Inspection and Maintenance Plan (IM Plan)

Falcon Storage Subdivision

Bent Grass Meadows Drive, Falcon, CO

SAND FILTER POND DETAIL
NOT TO SCALE

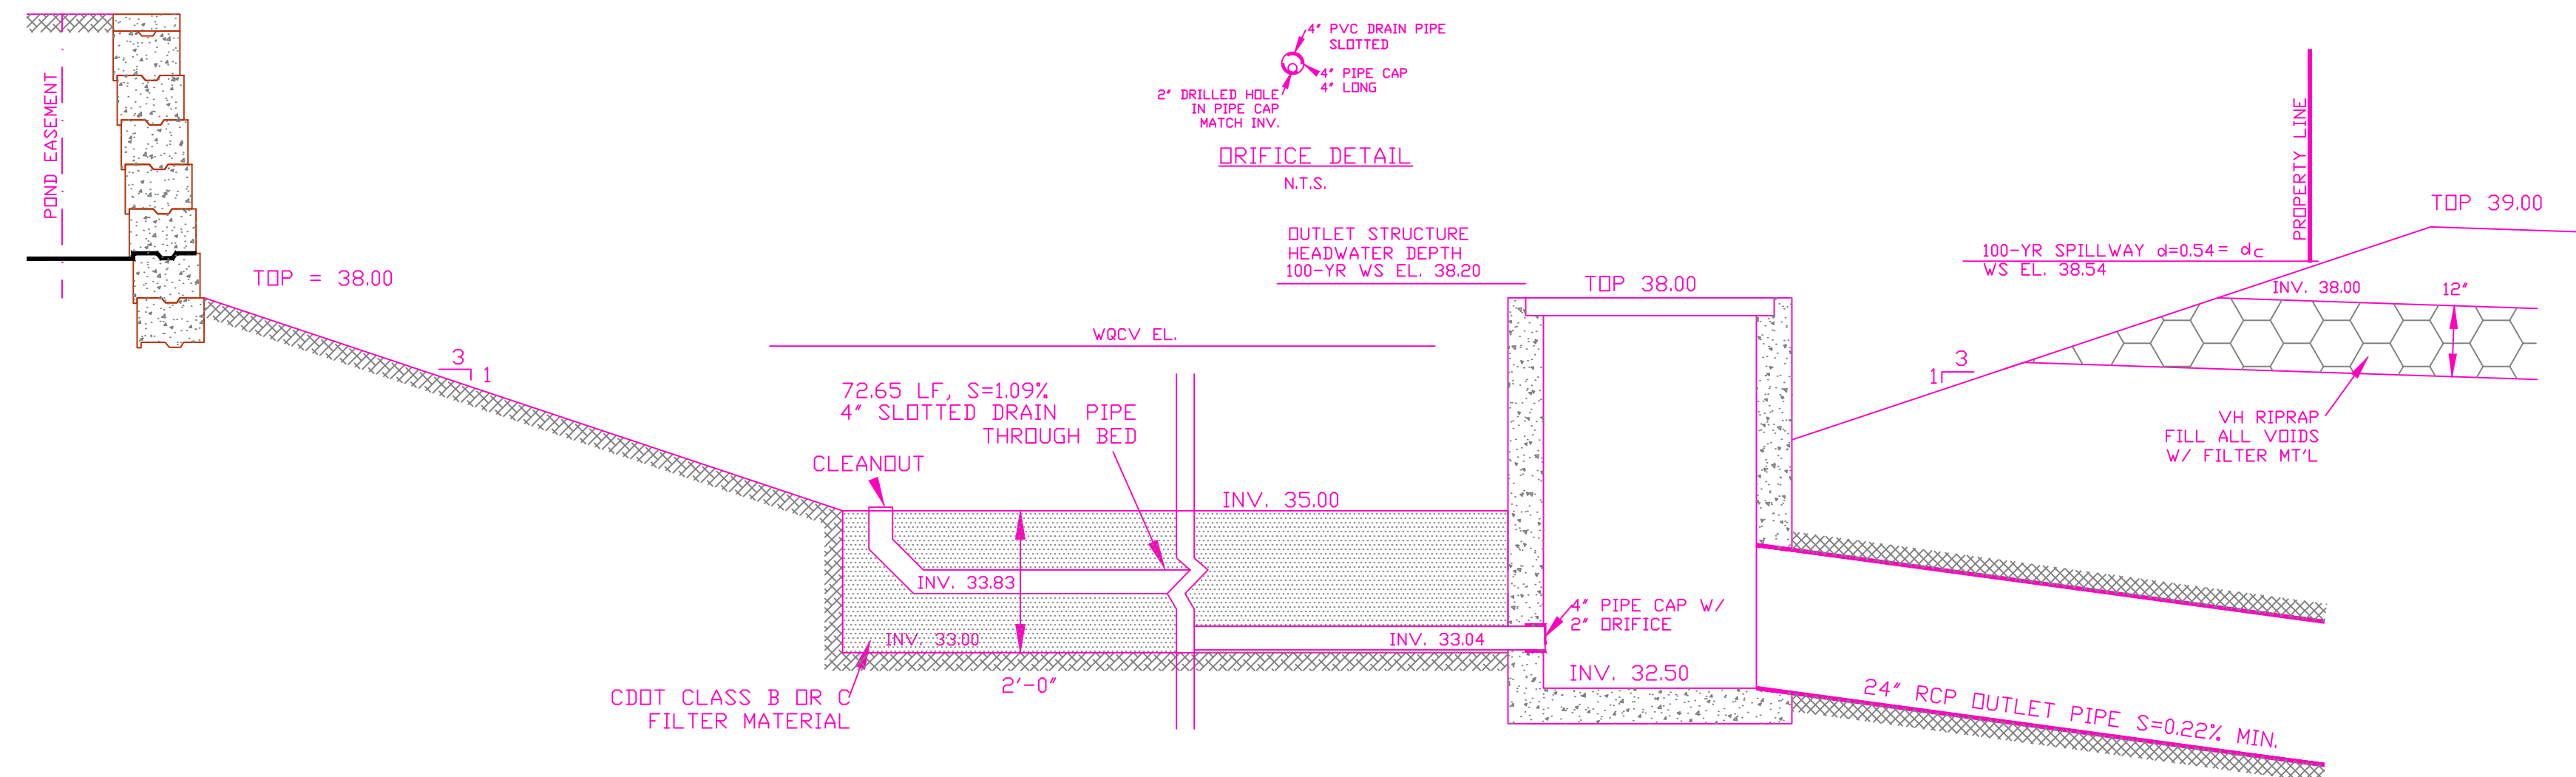
During the last review the SFB was referred to as a detention basin and MHFD Detention forms were provided. it now seems clear that the SFB is WQ only and the O&M should reflect such.

All stormwater is conveyed via curb and gutter and overlot to a sand-filter detention basin ^{water quality} ~~and full spectrum detention~~ ^{which provides} ~~than provide~~ water quality treatment ~~and full spectrum detention~~. Flows from the ~~detention~~ basin is conveyed in a major drainageway to a maintained regional detention storage facility just south of Woodmen Road.

The Site utilizes a sand filter ^{water quality} ~~detention~~ basin for providing water quality capture volume ~~and full spectrum detention~~ for the lot. ^{water is then routed down stream to a regional detention storage facility maintained by others.}
